Application for a non-material amendment following a grant of planning permission. Town and Country Planning Act 1990

PROPOSED SINGLE STOREY REAR EXTENSION WITH
ROOFLIGHT AND LANDSCAPE REAR GARDEN

75348 / APP / 2020 / 2686

8. Non-Material Amendment(s) Sought

DATE August 2020
SCALE 1:100
DRAWING NUMBER PL-139-1000
A1 SIZE DRAWING
Print Drawing at 1/50 For A1 size

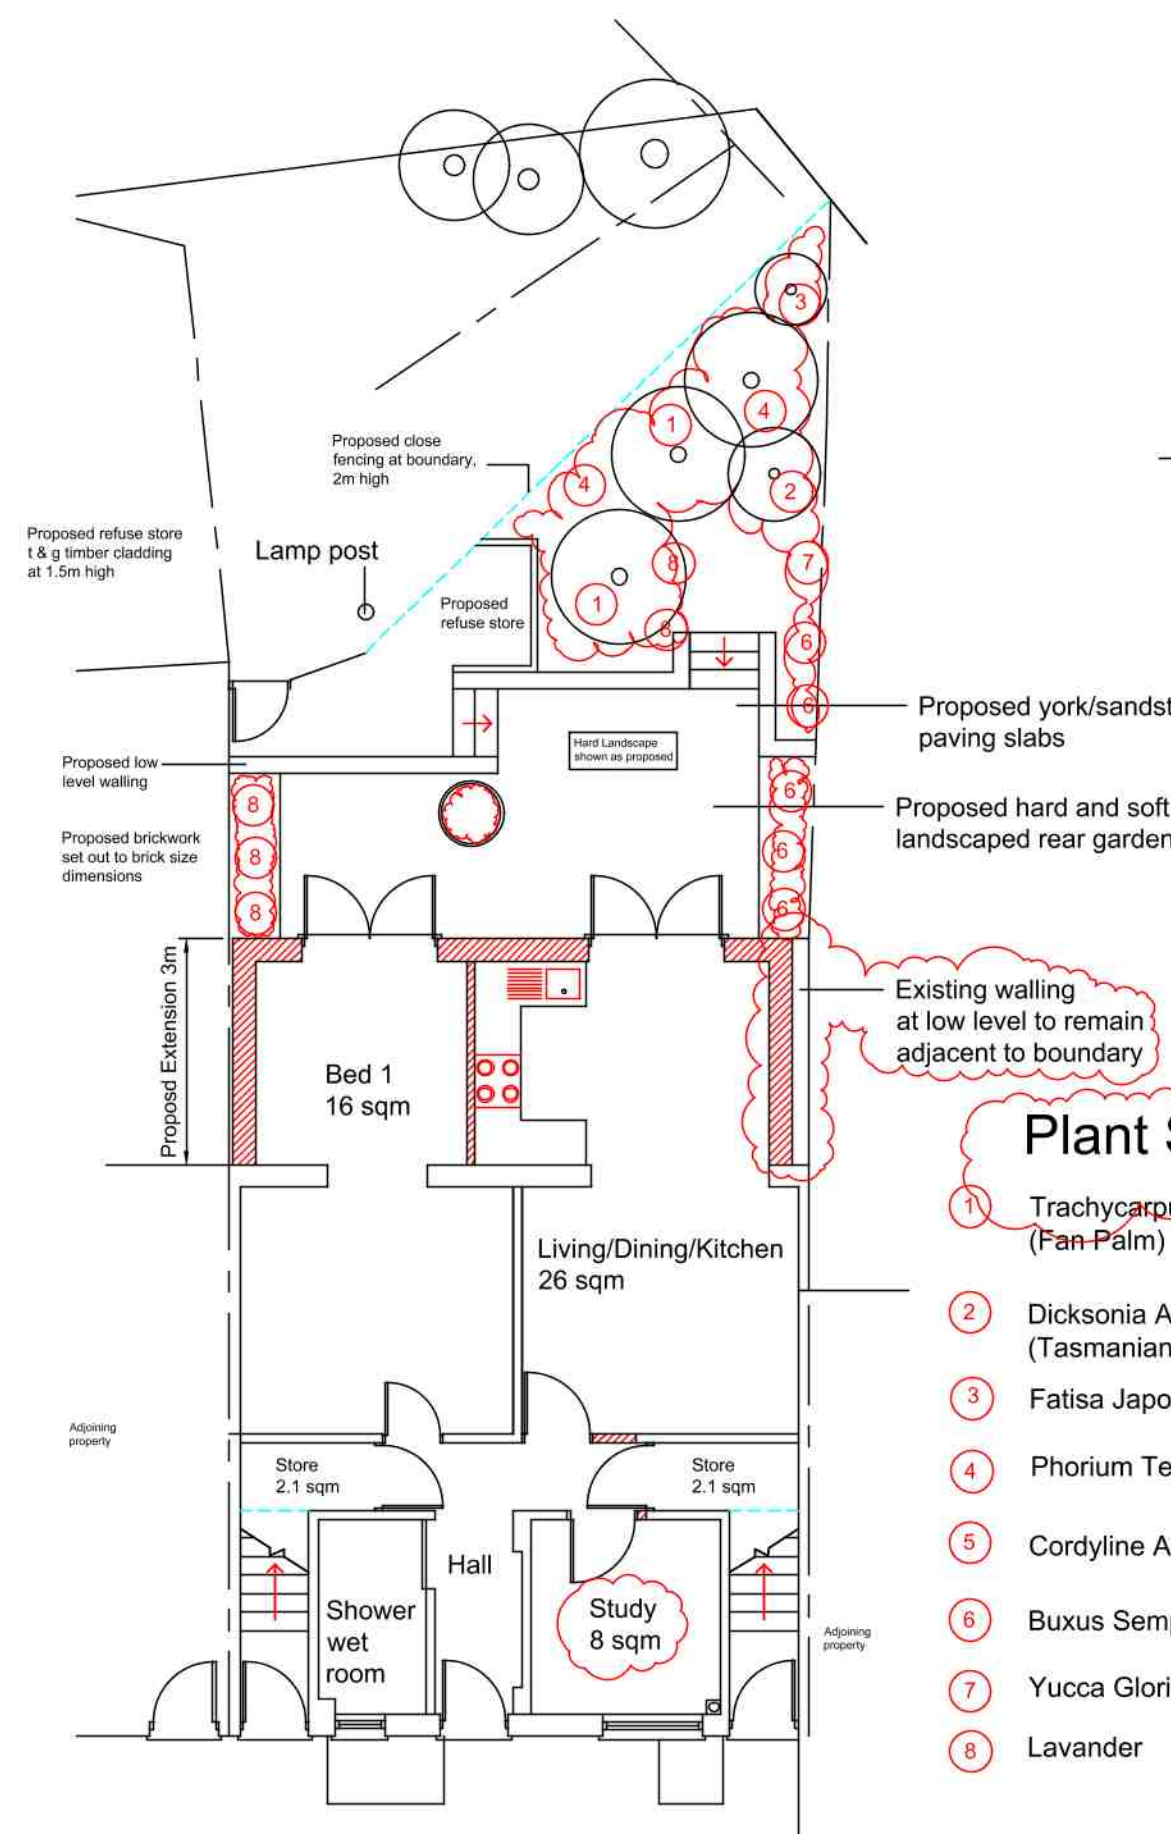
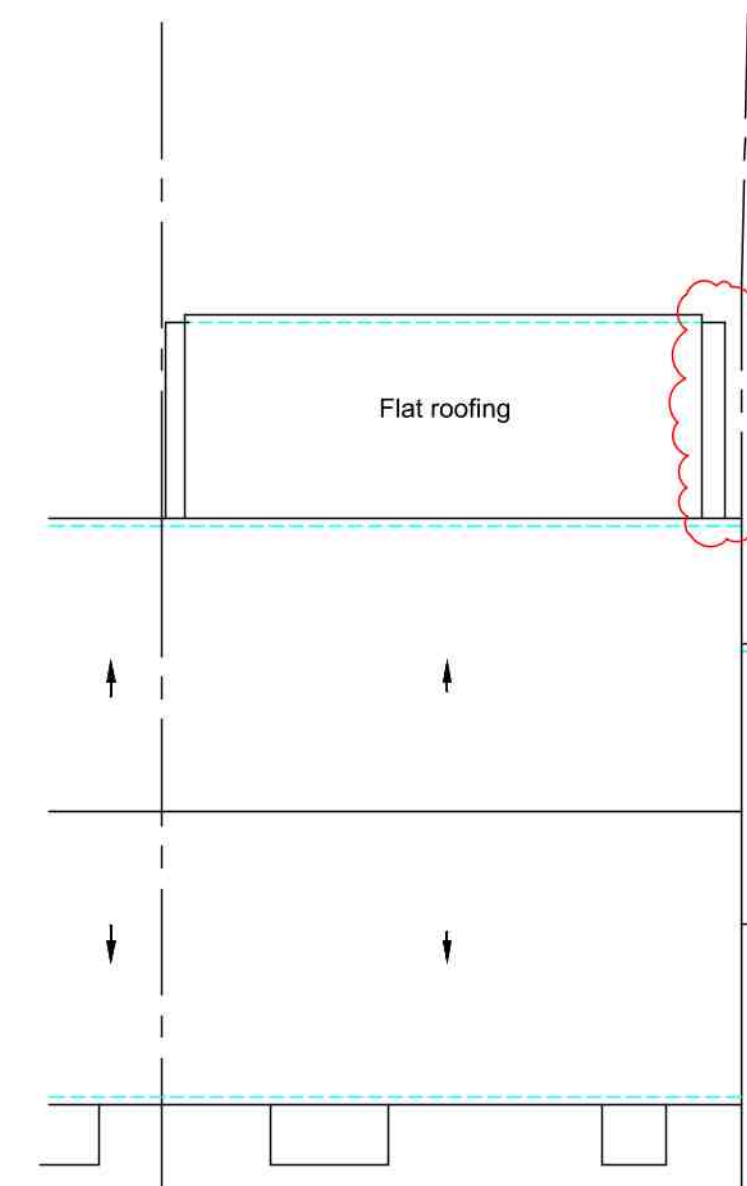
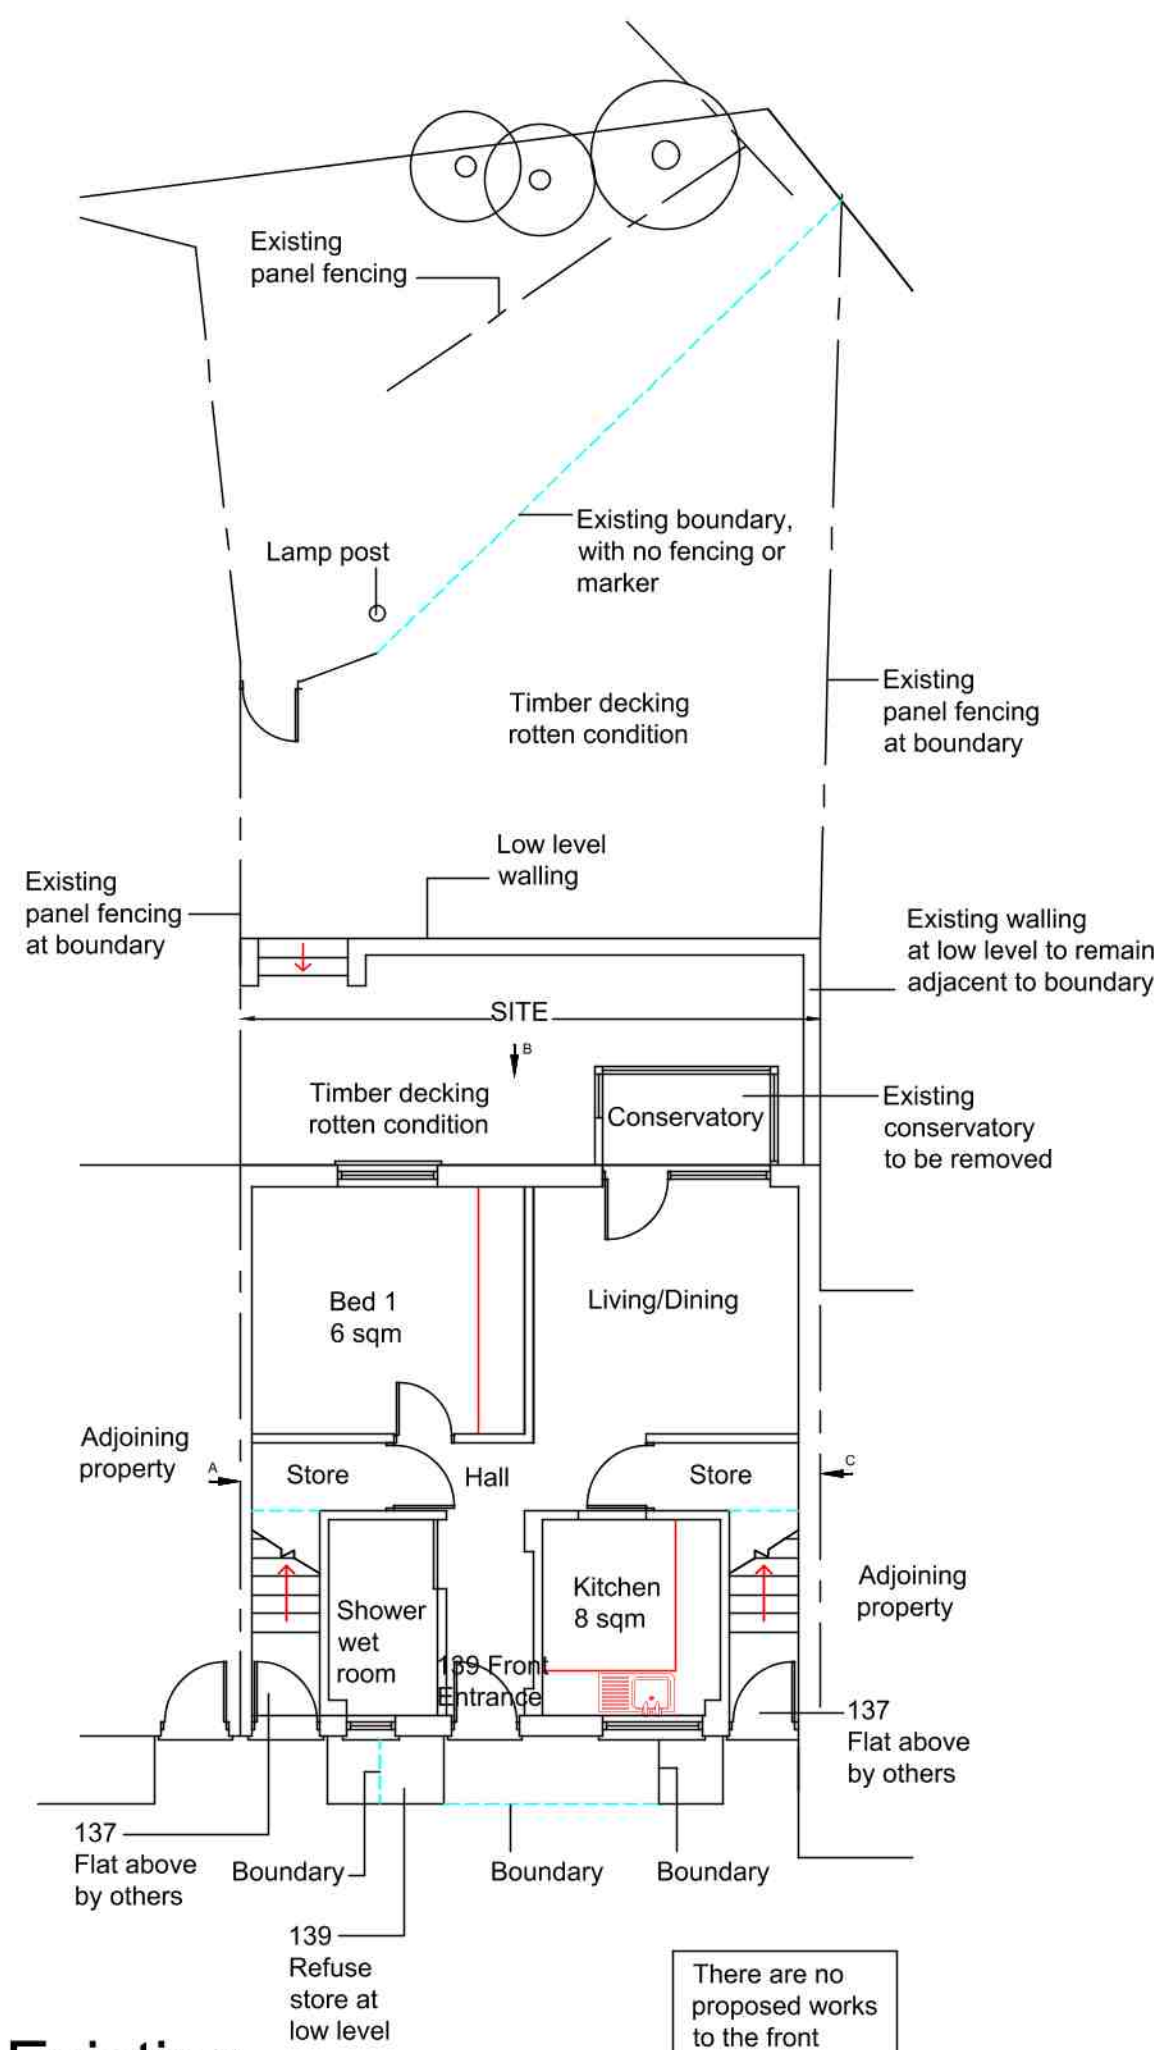
- 1/ INTERNAL ALTERATION & LANDSCAPE DESIGN
- 2/ REMOVAL OF PROPOSED ROOF LIGHT
- 3/ EXISTING LOW LEVEL RETAINING WALL AT BOUNDARY IS TO REMAIN, THEREFORE THE PROPOSED EXTENSION SIDE WALLING IS AMENDED TO ALLOW FOR RETAINING WALLING TO REMAIN
